NSW GOVERNMENT
Department of Planning

Our ref: MP 08_0222
Your ref:
File: S08/01725

Director General's Requirements for Global Switch Site Redevelopment (MP 08_0222).

Application number	MP 08_0222
Project	Construction of a new 6-storey specialist data centre building with 3 basement levels
Location	273 Pyrmont Road, Ultimo
Proponent	Global Switch Property (Australia) Pty Ltd
Date issued	10/2/09
Expiry date	If the Environmental Assessment (EA) is not exhibited within 2 years after this date, the applicant must consult further with the Director-General in relation to the preparation of the environmental assessment.
Key issues	The EA must address the following key issues: 1. Relevant Environmental Planning Instruments (EPIs) policies and Guidelines to be Addressed: • State Environmental Planning Policy (Major Projects) 2005 • State Environmental Planning Policy (Infrastructure) 2007 • State Environmental Planning Policy No. 55 – Remediation of Contaminated Sites • Sydney Regional Environmental Plan (Sydney Harbour Catchment) 2005 • Sydney Harbour Foreshores & Waterways Area DCP • Darling Harbour Development Plan No.1 • Ultimo Pyrmont Section 94 Contributions Plan, and • The Former

proj no.
 4019-00
 drwg no.
 arskDG17

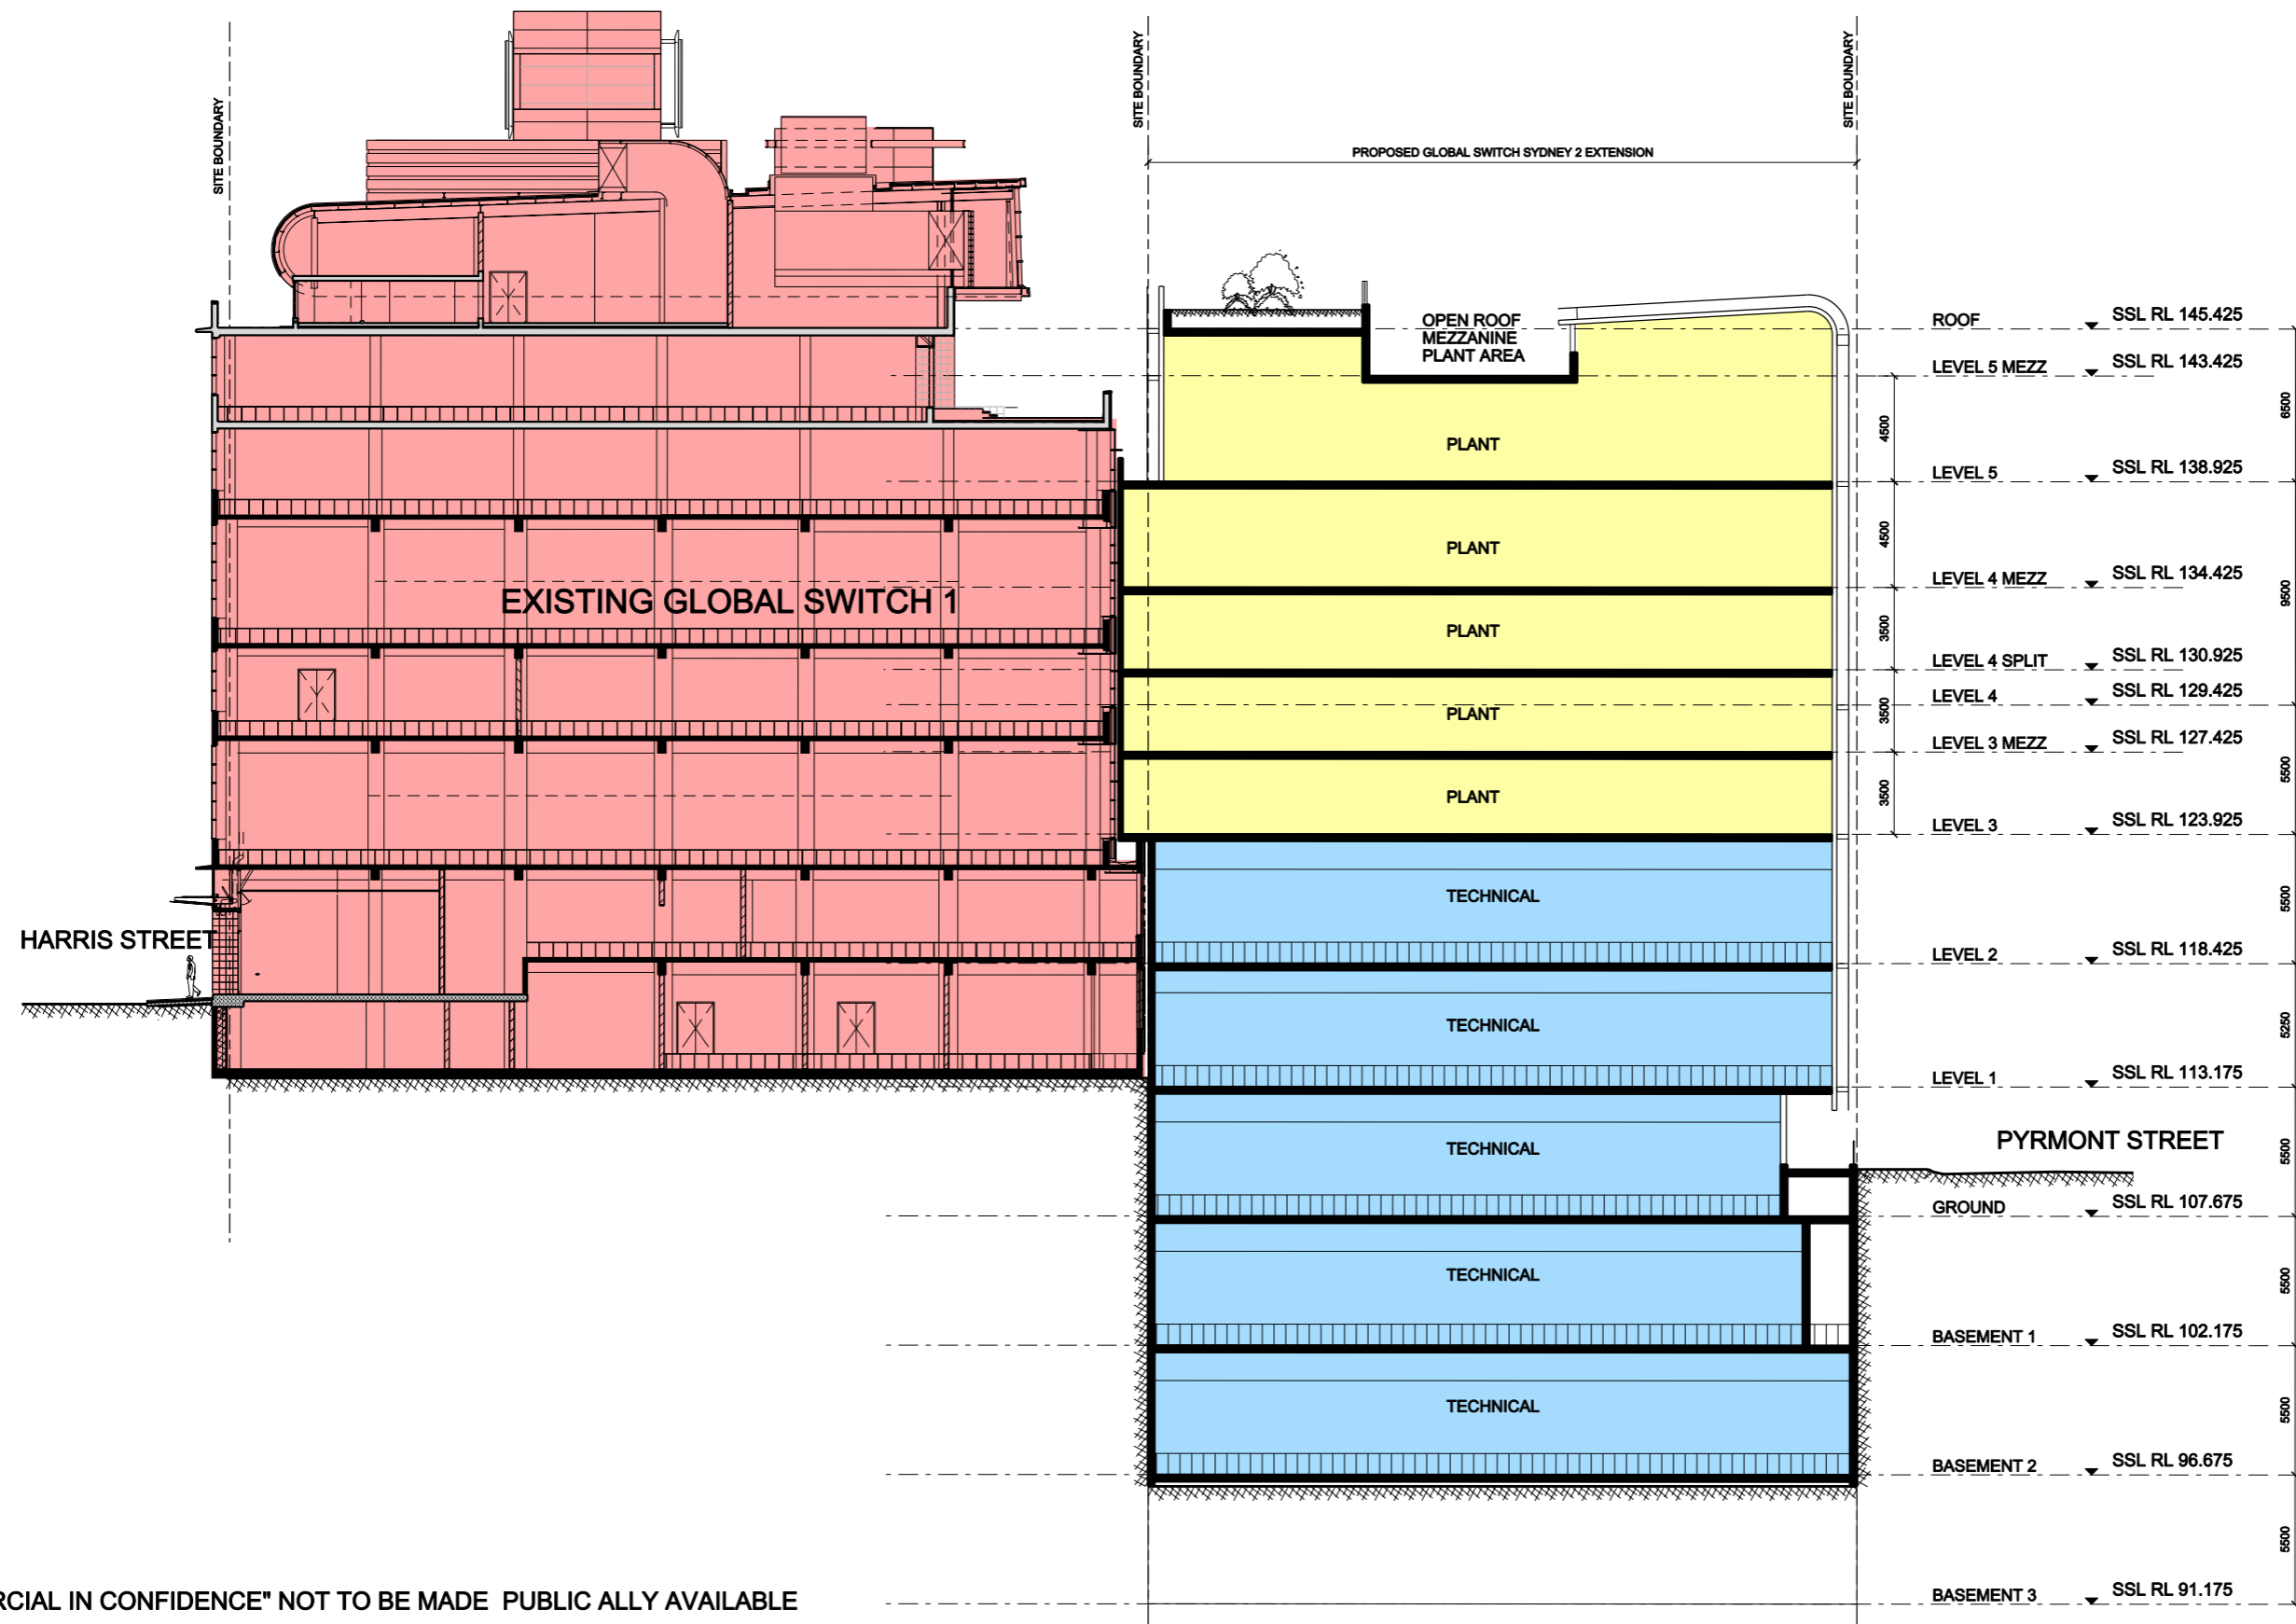
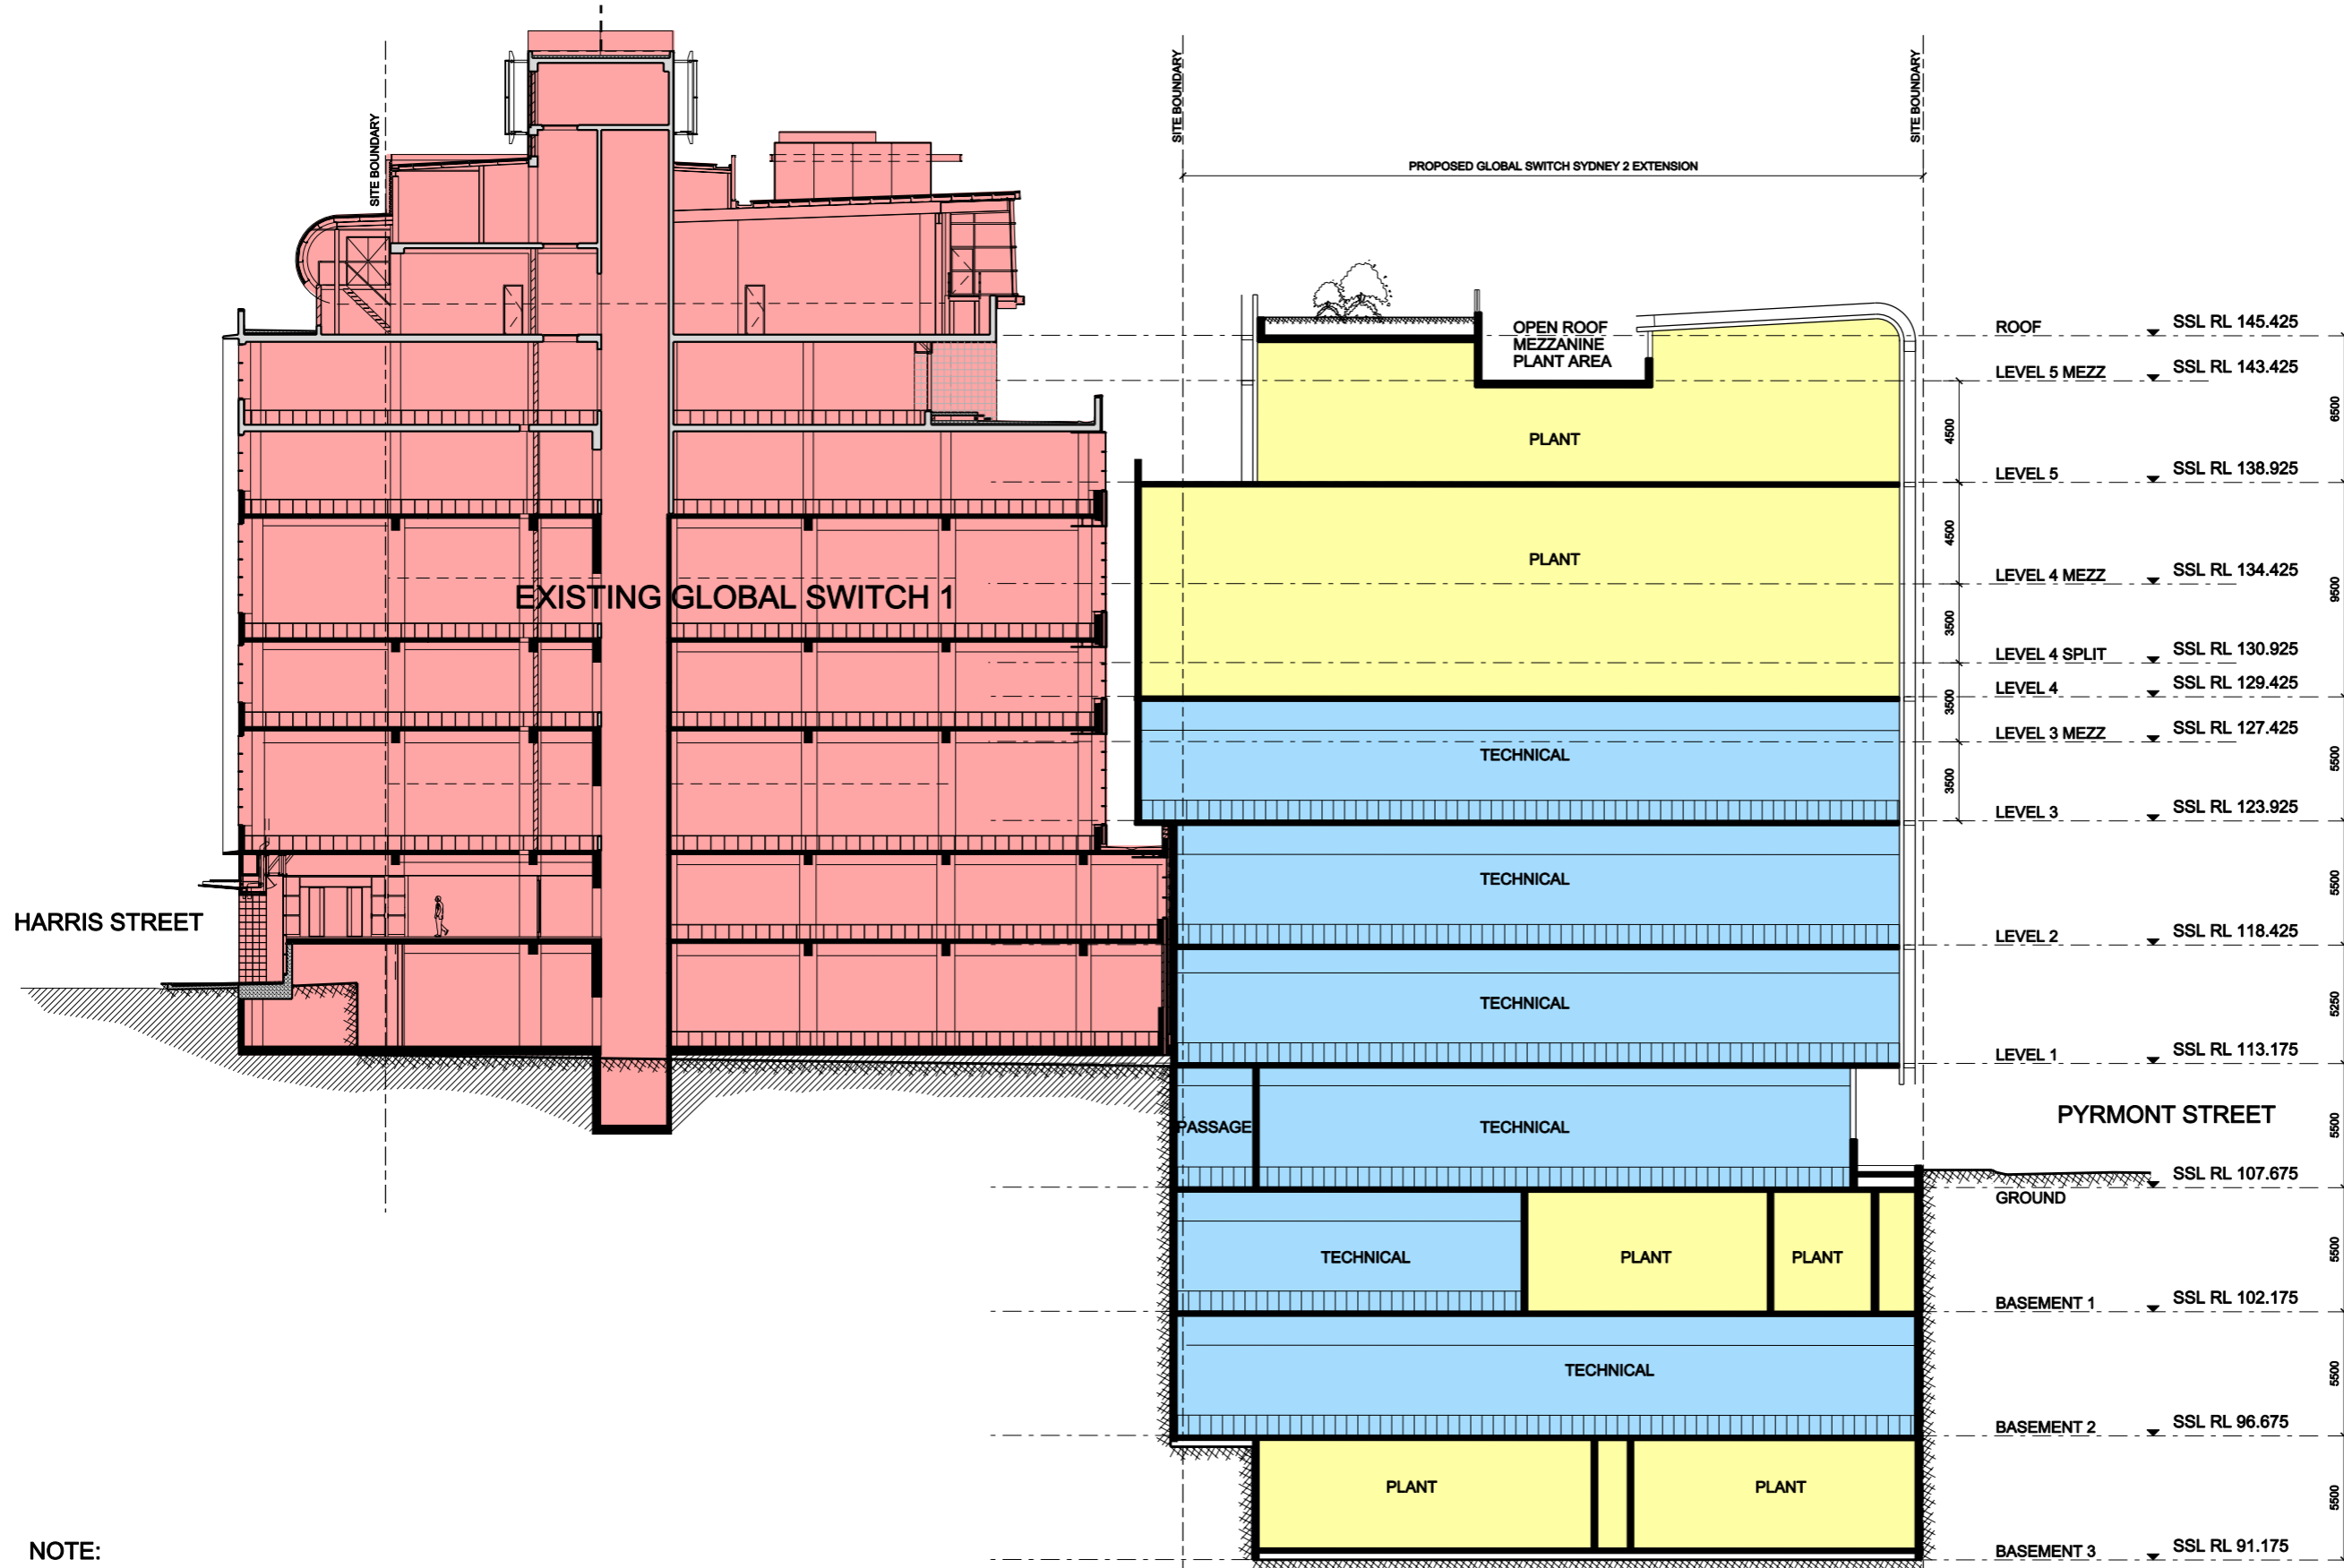
The previous design for the development incorporated both a visual and physical link between the existing Global Switch building and the proposed building. The proposed building provides only a minimal setback from the existing Global Switch building, which limits both access and the line of sight through the site. Whilst it is appreciated that Harris and Pyrmont Streets may provide satisfactory physical connections around the site, it is considered that at least a visual link from Goldsbrough Mort to the Bullecourt Development should be maintained. Accordingly, it is suggested that you consider an additional setback to increase the visual separation between the buildings, particularly at the upper levels.
